AA | LAN900200

14 August 2025

**SUBJECT: CENTRAL-WEST ORANA REZ TRANSMISSION MODIFICATION 2 -
MUDGEE MAINTENANCE FACILITY (SSI-48323210-MOD-2)**

Figure 10 – Castlereagh Highway / Hill End Road AM Peak (left) and PM Peak (right) intersection turning counts (Source: Colliers, Thursday 13 February 2025)

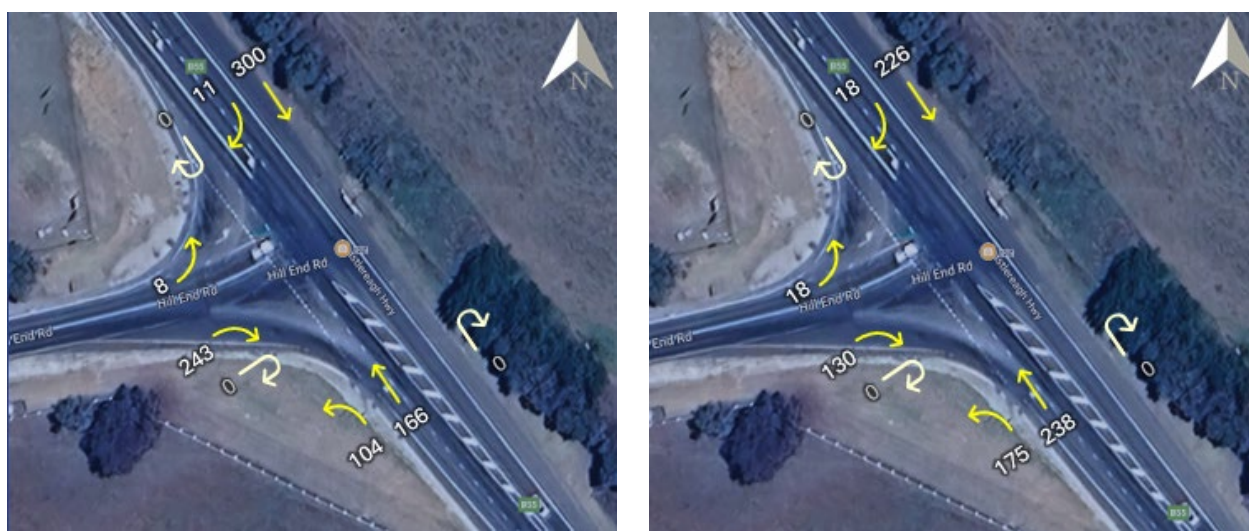
Midblock traffic volume counts on Castlereagh Highway north of Mudgee and turning movement counts at the Castlereagh Highway / Hill End Road intersection show that traffic volumes are relatively low and LOS A predominates. It is noted that the midblock counts were undertaken in 2022 and as such the data could be considered somewhat outdated.

Figure 15 – Construction Phase Trip Distribution at Hill End Road / Castlereagh Highway Intersection

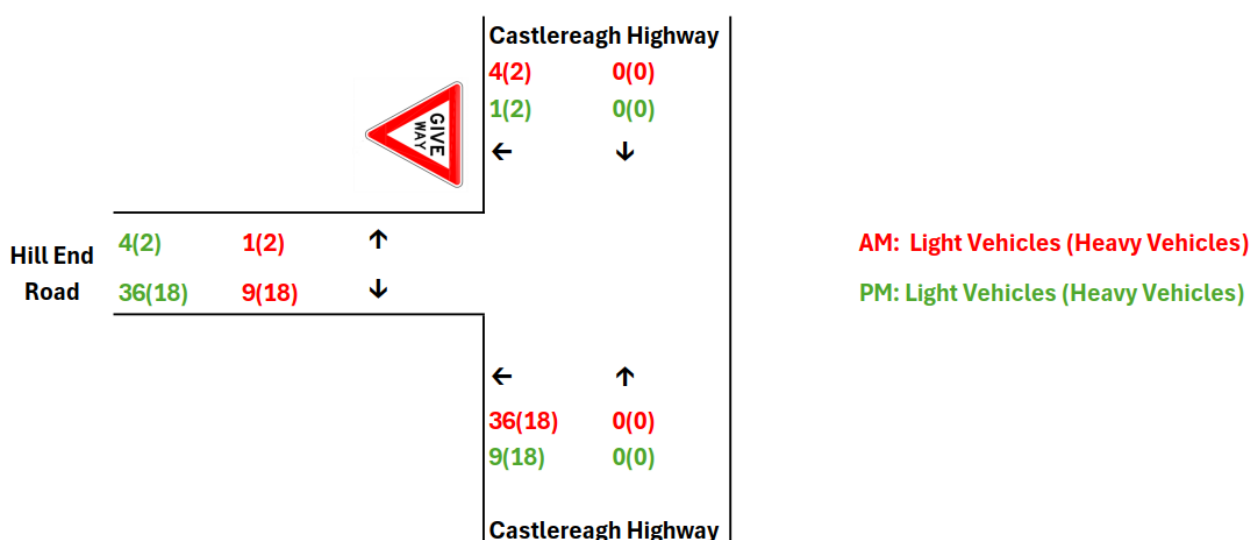
The proposed development is expected to generate an average of about 40 vehicle movements per day, whilst a maximum of 90 vehicle movements per day is expected to be generated during peak construction. The assessment is based on a highly conservative

assumption of 90 vehicle movements in both the AM and PM peak periods (total daily volume of 180 vehicle movements).

Council requests that ongoing monitoring during construction should be required, especially given the cumulative regional projects.
